Re: 34 Aldwick Gardens

Please find attached the follow drawings in pdf format:
20 5b indicates the proposed addition as approved AW/102/19/HH
20 5c indicates the proposed addition as proposed subject to AW/27/20/HH.

project: 19/C1
drawing no: 5b
date: Feb 2019

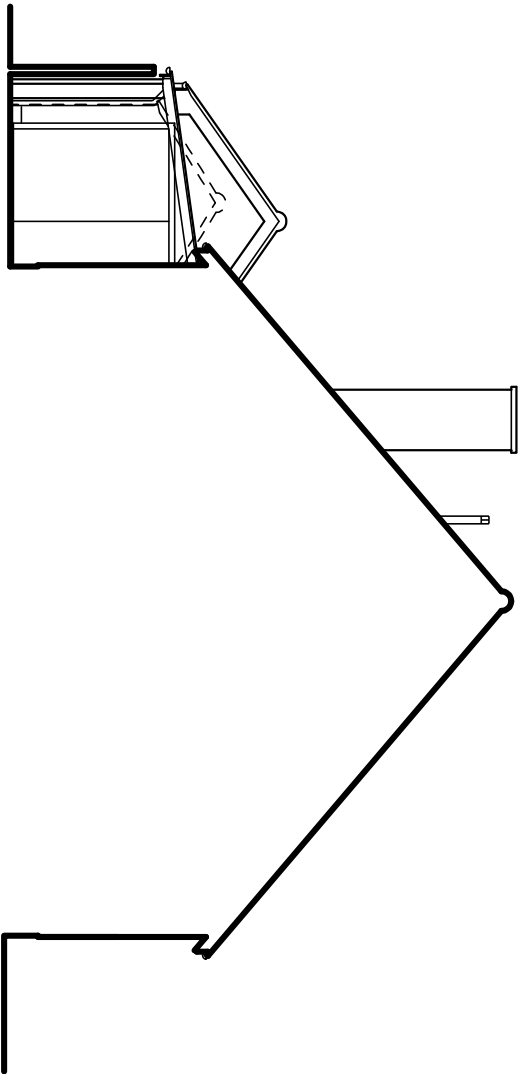
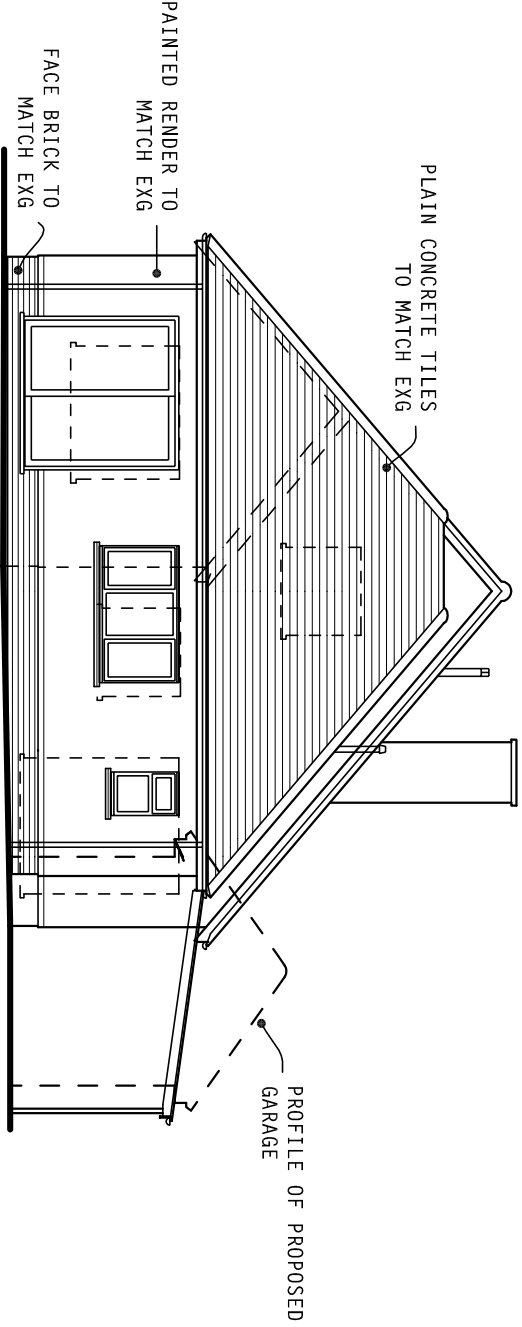
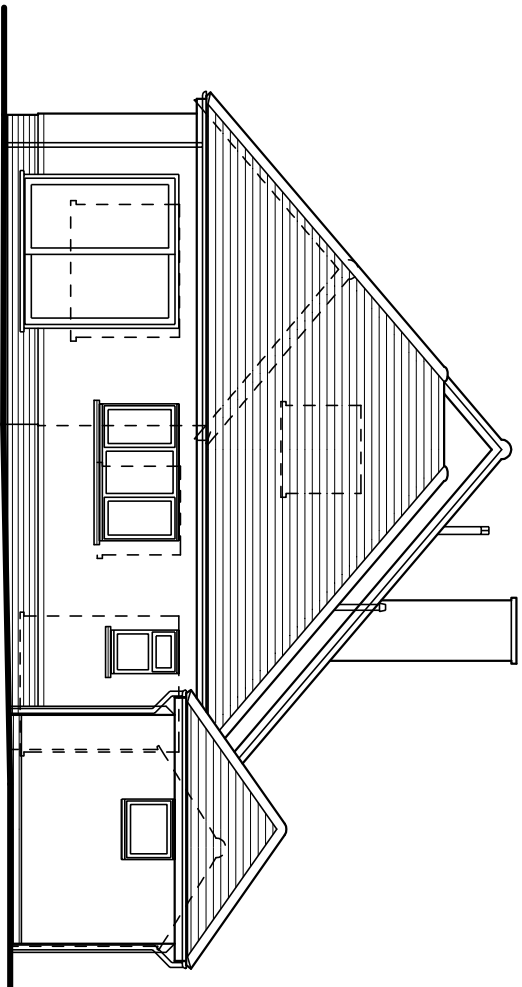
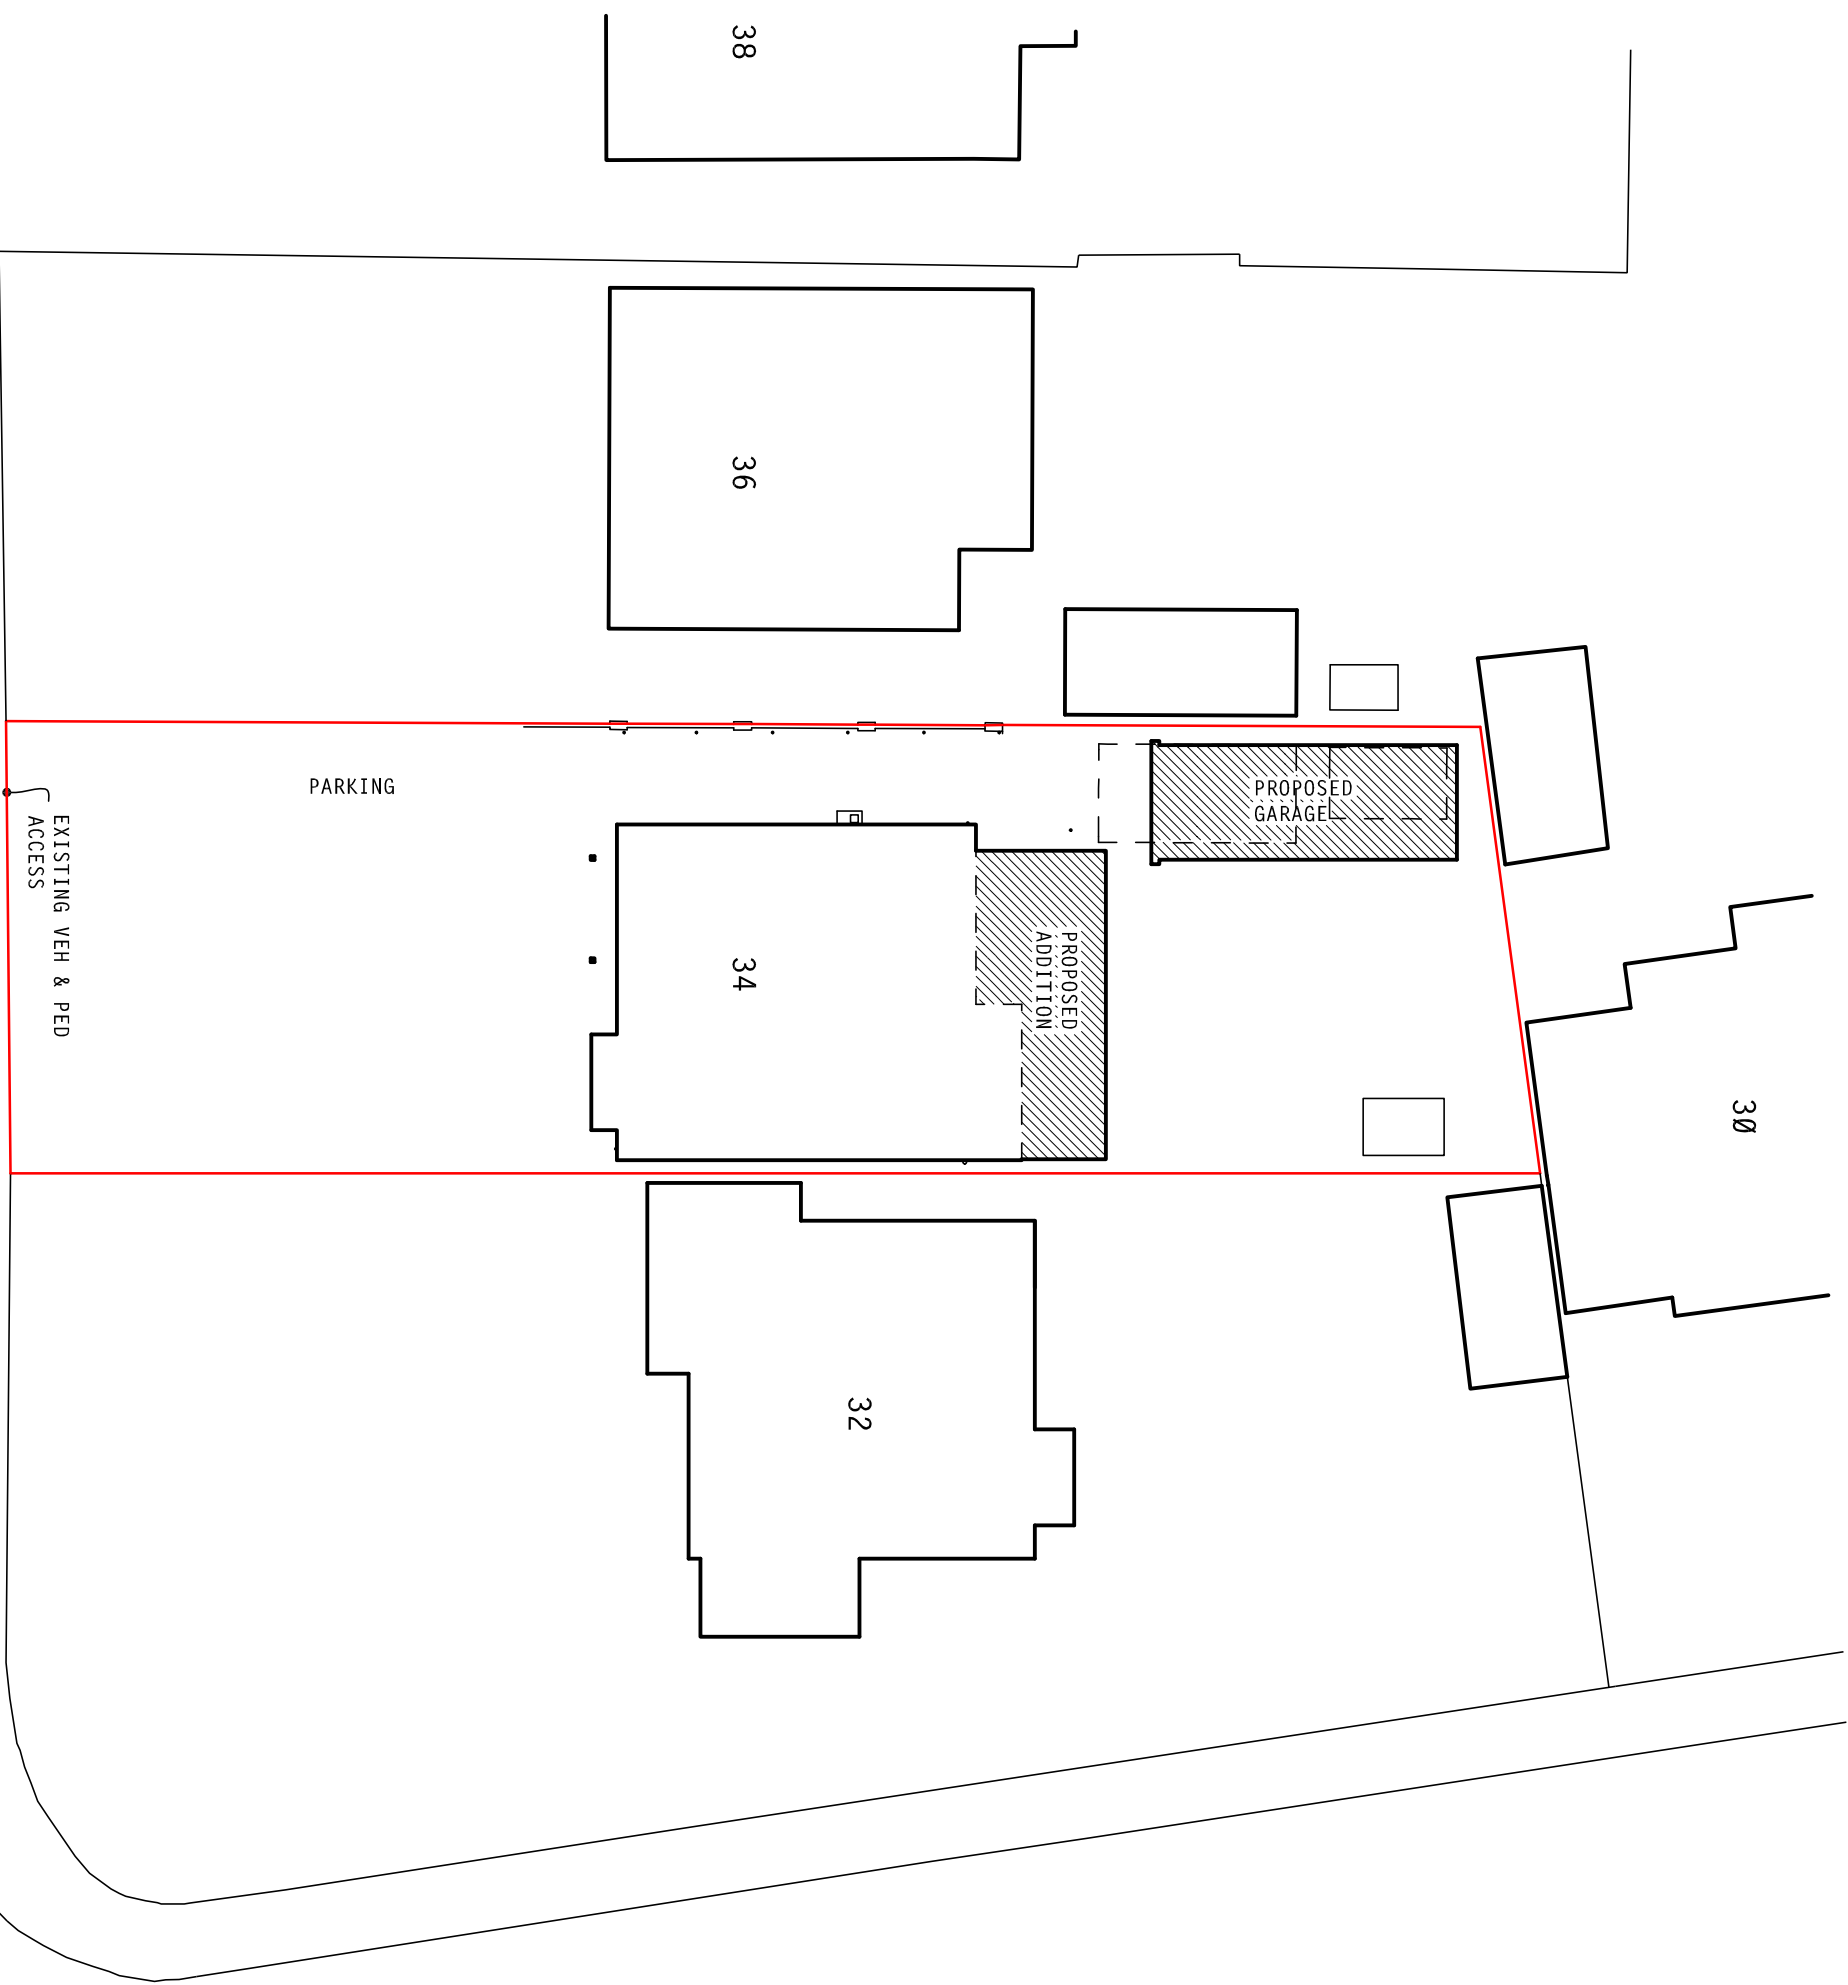
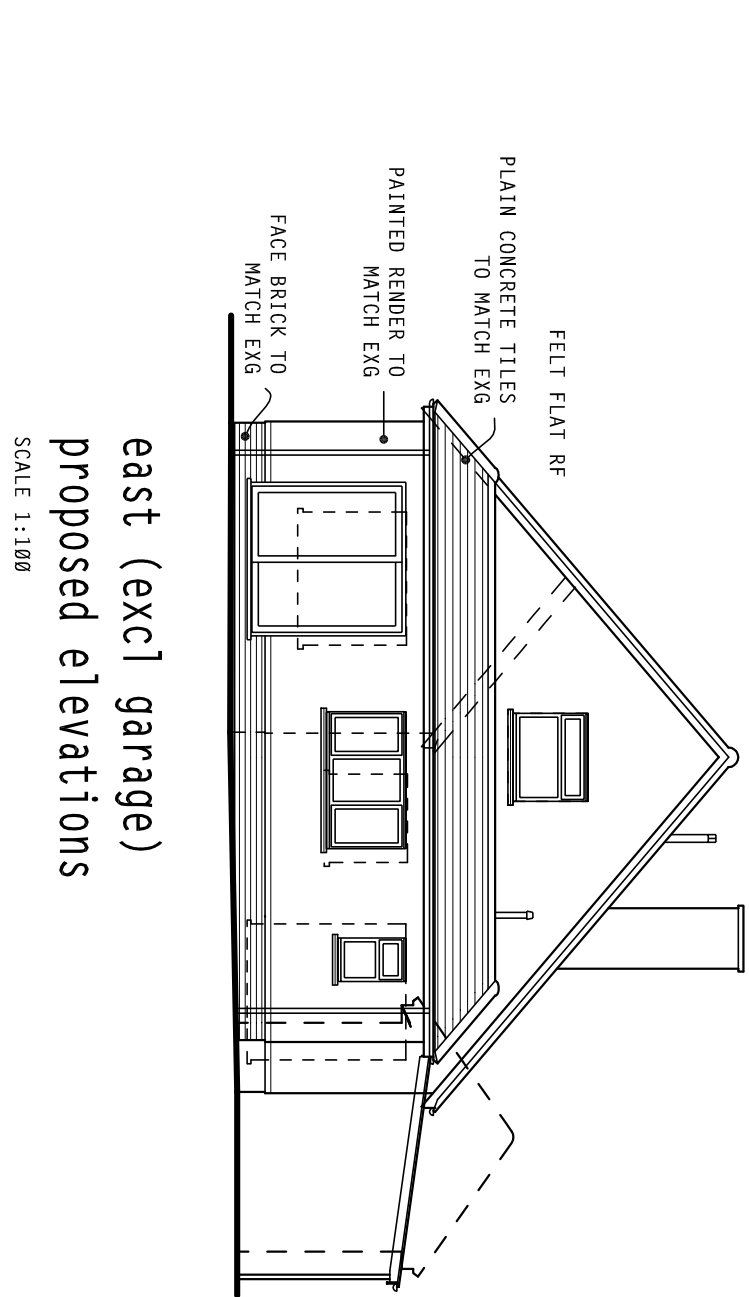
Please note the differing addition roof designs, as previously approved tiled roof and as now proposed part tiled and part flat roof. This being the only change from the previous approved scheme.
